**Consultation Response from Mike Hibbert,
KC Waste Strategy(Refuse & Recycling)**

2022/93154 Land at, Penistone Road, Fenay Bridge, Huddersfield, HD8 0AW Land at, Penistone Road, Fenay Bridge, Huddersfield, HD8 0AW

Erection of 68 dwellings with associated access, parking, open space, landscaping and infrastructure works (including installation of surface water attenuation tank)

Responding Ref: WPS 23-026

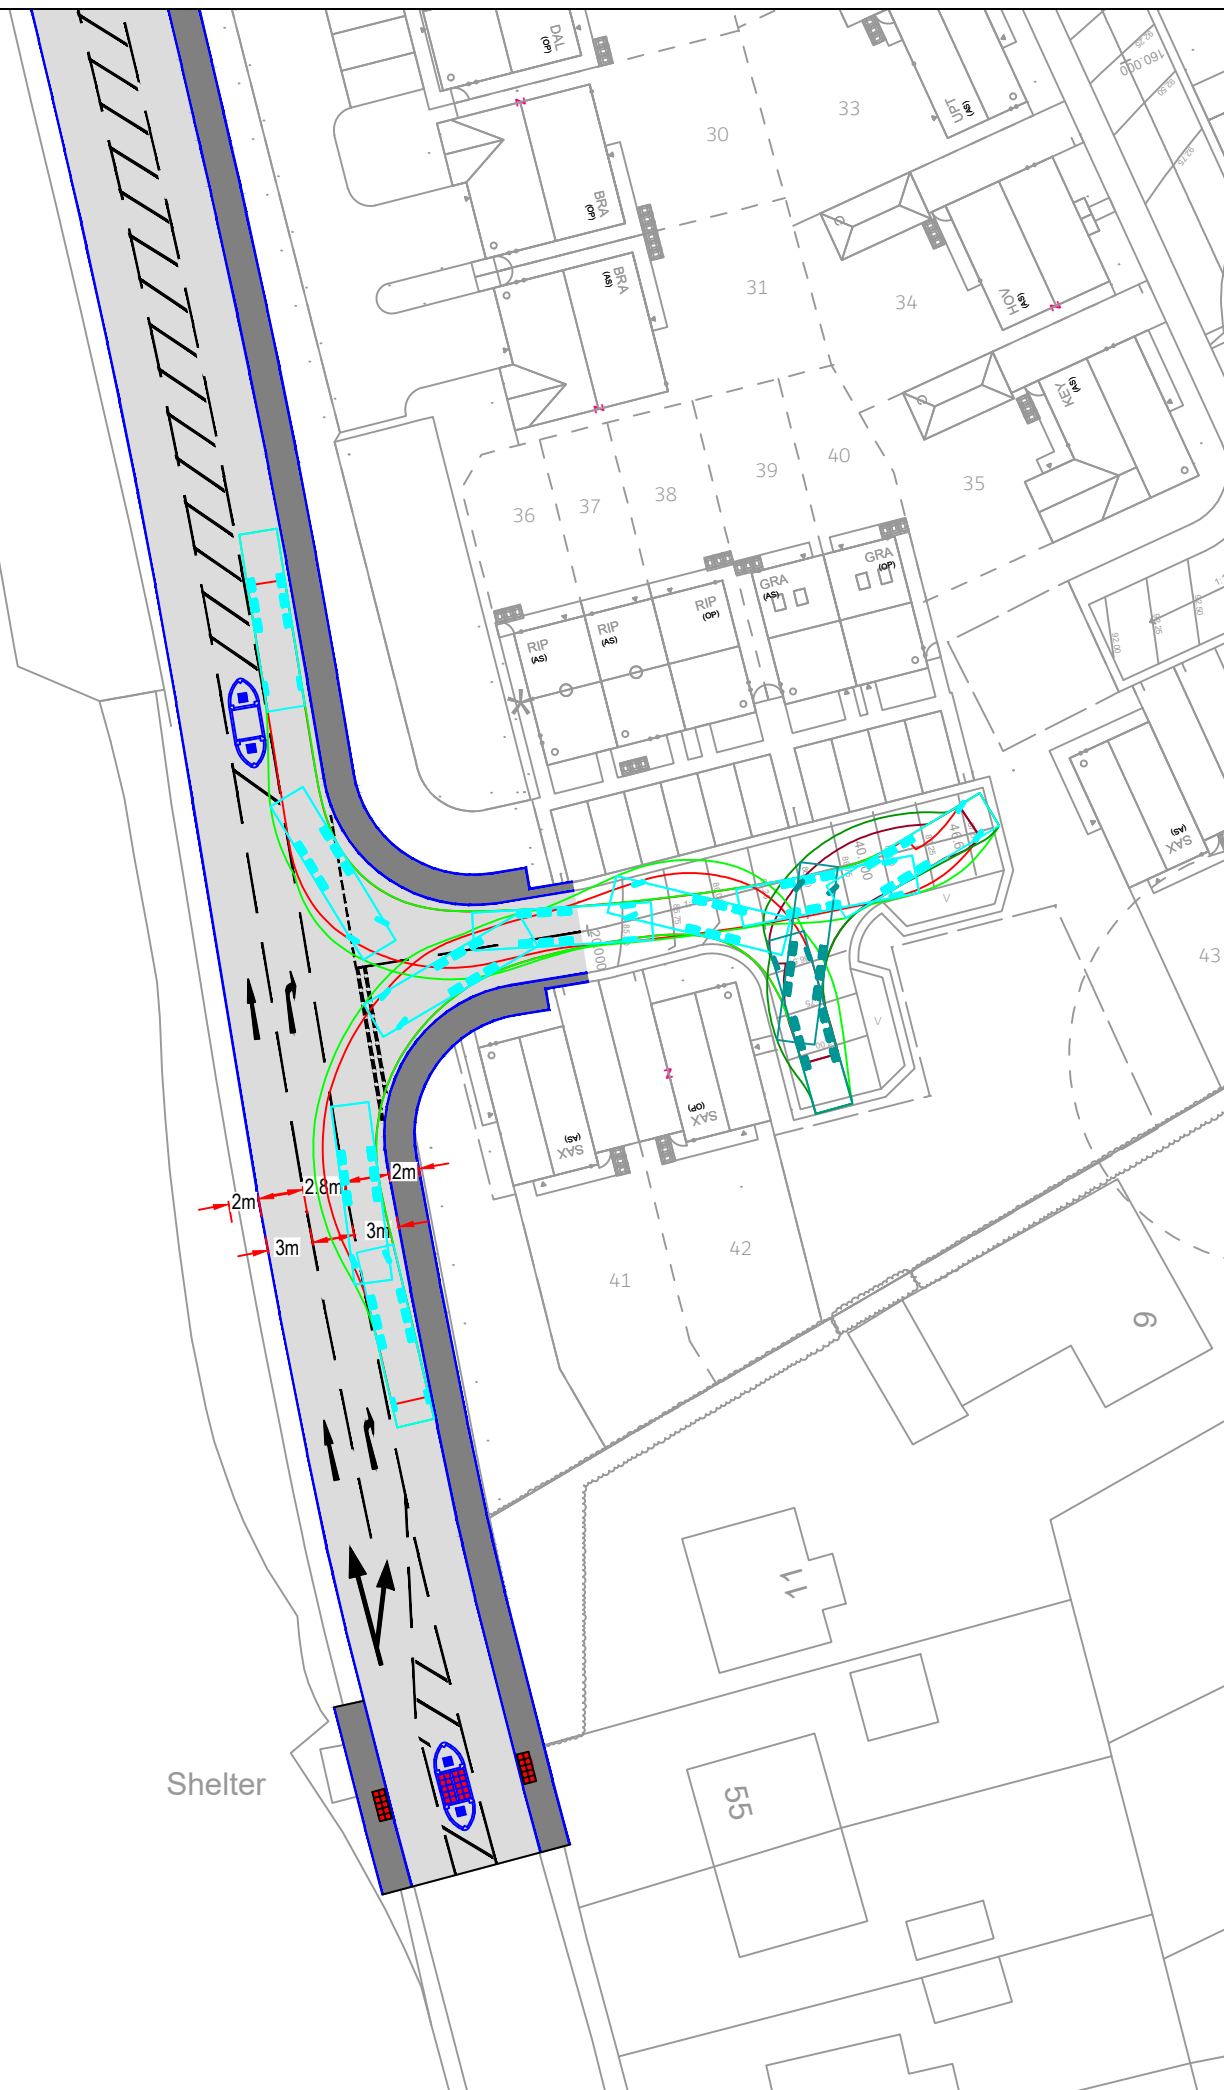
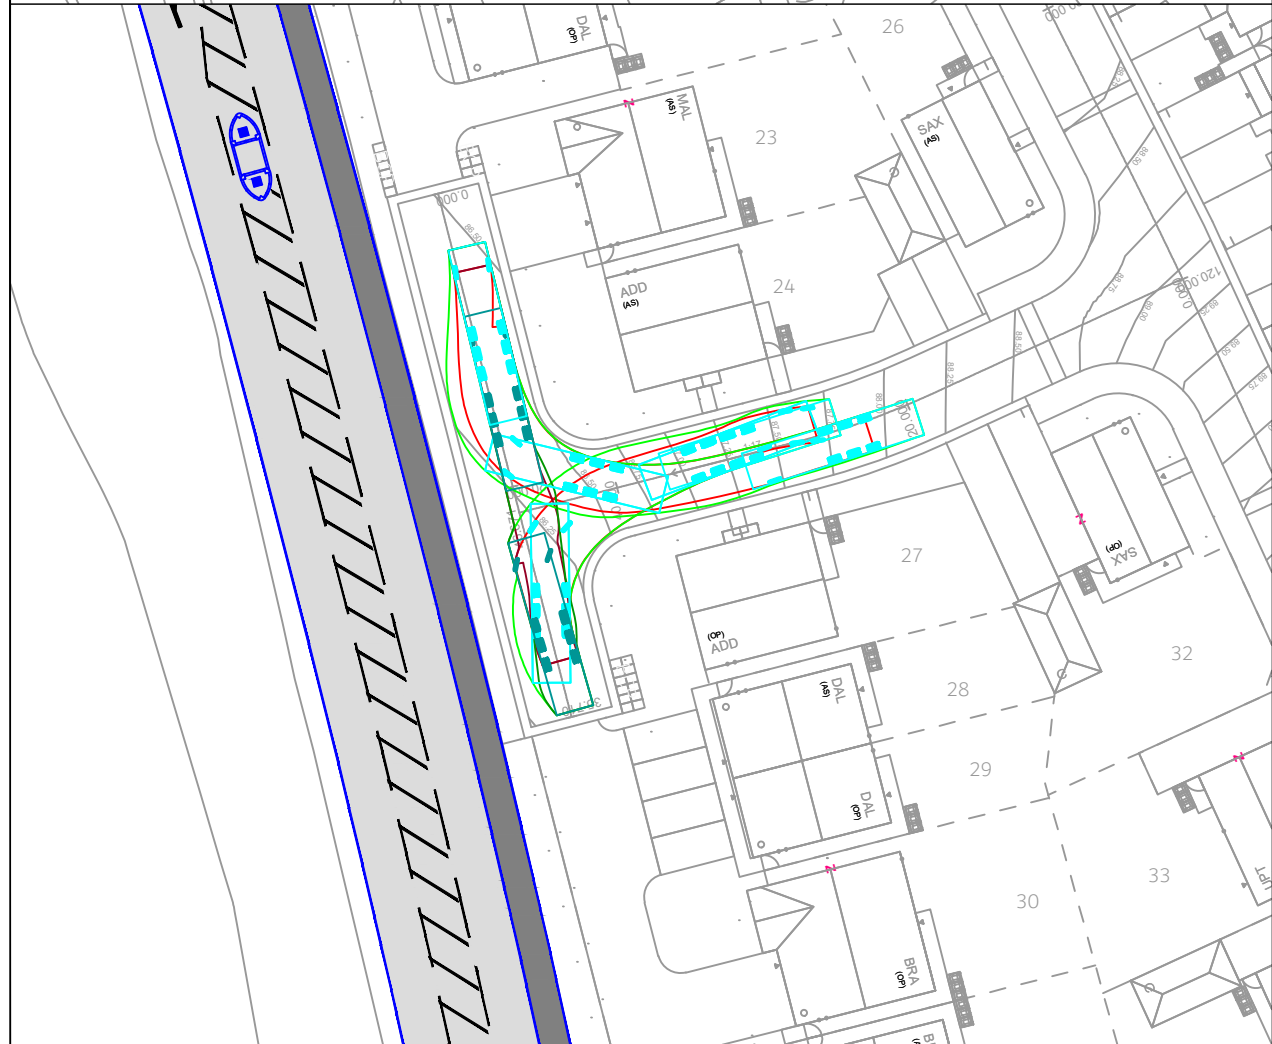
The proposed road layout includes four turning heads on the site, each of which will necessitate the reversing of a refuse collection vehicle. These turning heads are active but all measures should be taken to prevent blockage by parked cars. Parking in the turning heads is unacceptable as a long reversing manoeuvre through the site it is potentially hazardous for both residents and waste collection crews. **The turning head arrangement at the South of the site between Plots 40 and 42 has the potential to be blocked by parked cars and if this is the case an RCV would have to reverse in/ out from Penistone Road that is unacceptable.**
